DECISION DELEGATED TO DEVELOPMENT MANAGER

Application No: H21-0442-21 **Applicant:** Mr S Necker

Proposal: Erection of a 4-bay garage with storage above to serve dwellings on plots 3 and 4, 29 Station Road, Tydd Gote, approved under H21-0489-20.

Location: 29 Station Road Tydd Gote Wisbech

Site Plan

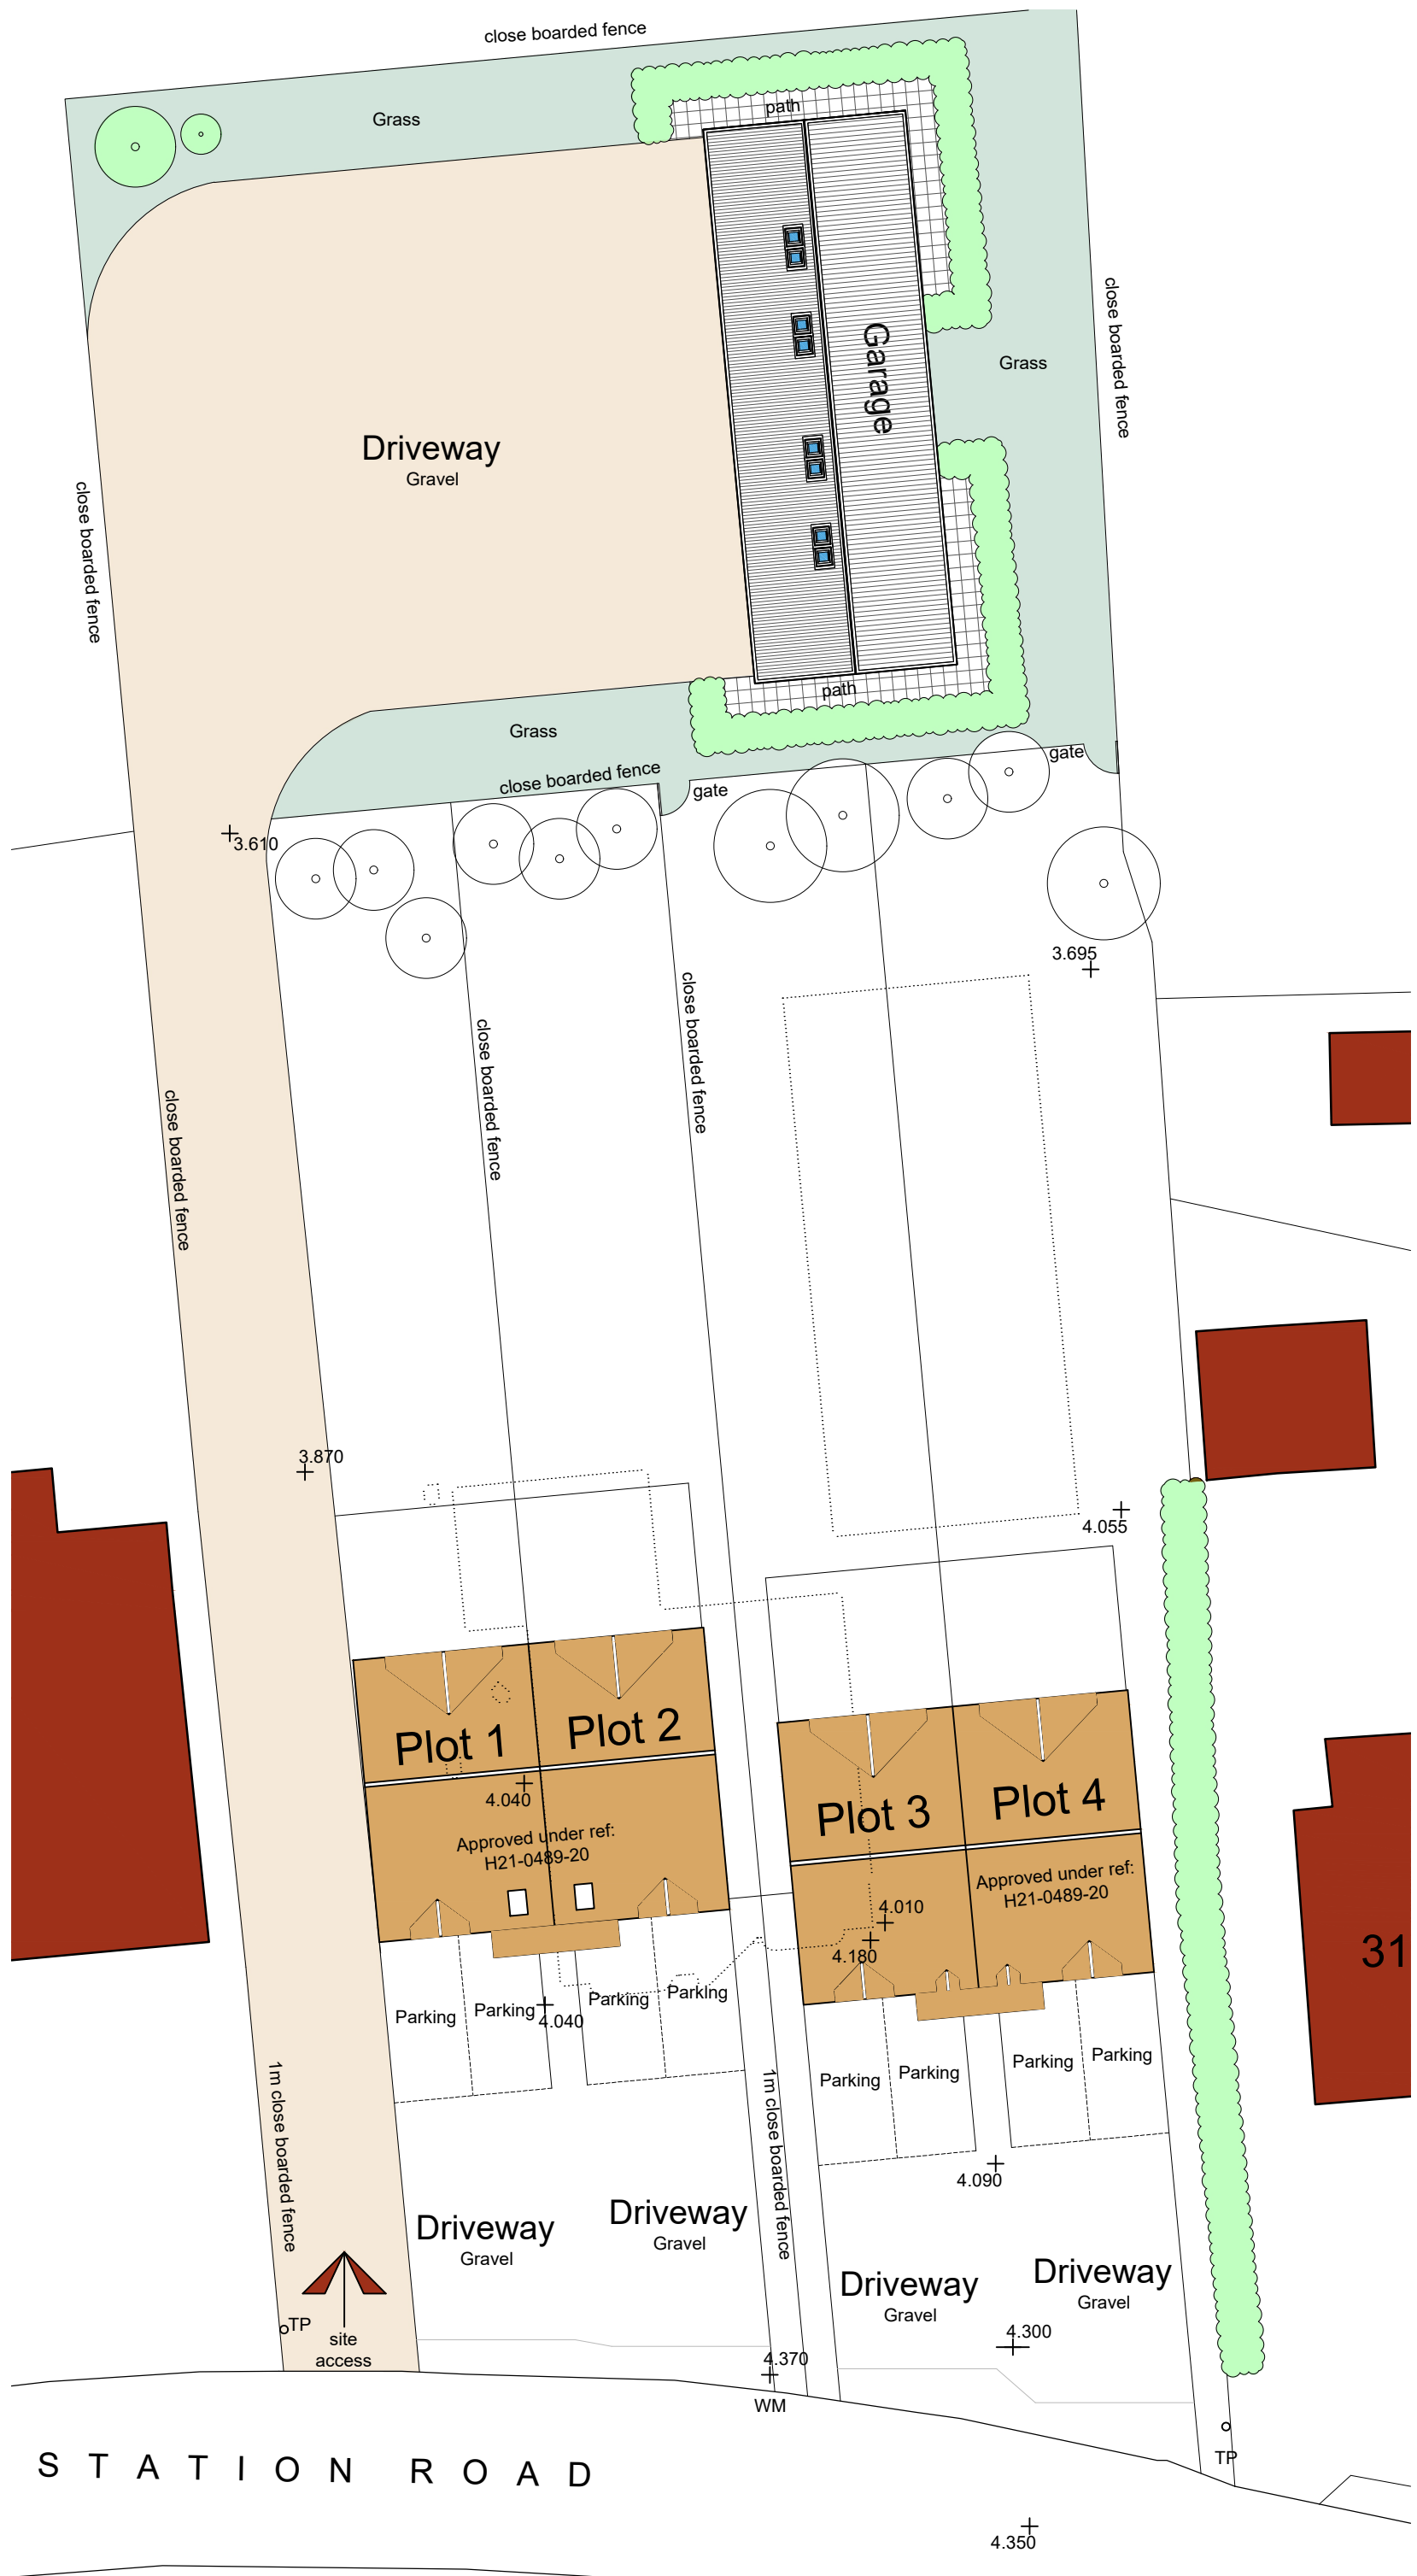
Highway safety: The roadway to the garages is only single vehicle width which could lead to hold ups in traffic on Station Rd which currently has speeding and accident issues under investigation.

Noise: A gravelled roadway running so close to the neighbouring property would have major impact on the residents use of their amenity. Council recommend that should this application be granted a tarmacked roadway be a stipulated condition.

Access road not wide enough for 2 cars to pass safely; Highway safety issues; Lights shining in windows during darker months; Noise/disturbance from vehicles and gravel cause health issues; Unnecessary; Could be converted to dwelling at a later stage; Tree planting close to boundary cause structural issues; No gates in fence that has been erected; Where are garages for plots 1 and 2.

Plots 3 and 4 have 2 car parking spaces along their frontage. The proposal would provide additional undercover parking. Vehicular access would be via a gravelled private roadway, which should include a 2 metre hardsurfaced apron at its entrance. Concerns have been expressed over vehicles having to reverse out onto Station Road if meeting along the private driveway. However, this would be infrequent due to the low level of vehicles movements associated with a domestic use. In such an event, a large turning area is available for use immediately in front of the garages, which could be used for the manoeuvring and turning of vehicles.

LCC Highways have been consulted and have indicated that the new access arrangements meet the guidelines as set out in "Manual for Streets" and that adequate provision has been made within the site to allow vehicles to turn so they can enter and leave in a forward gear. Therefore, it is considered that the proposals would not result in an unacceptable impact upon highway safety.
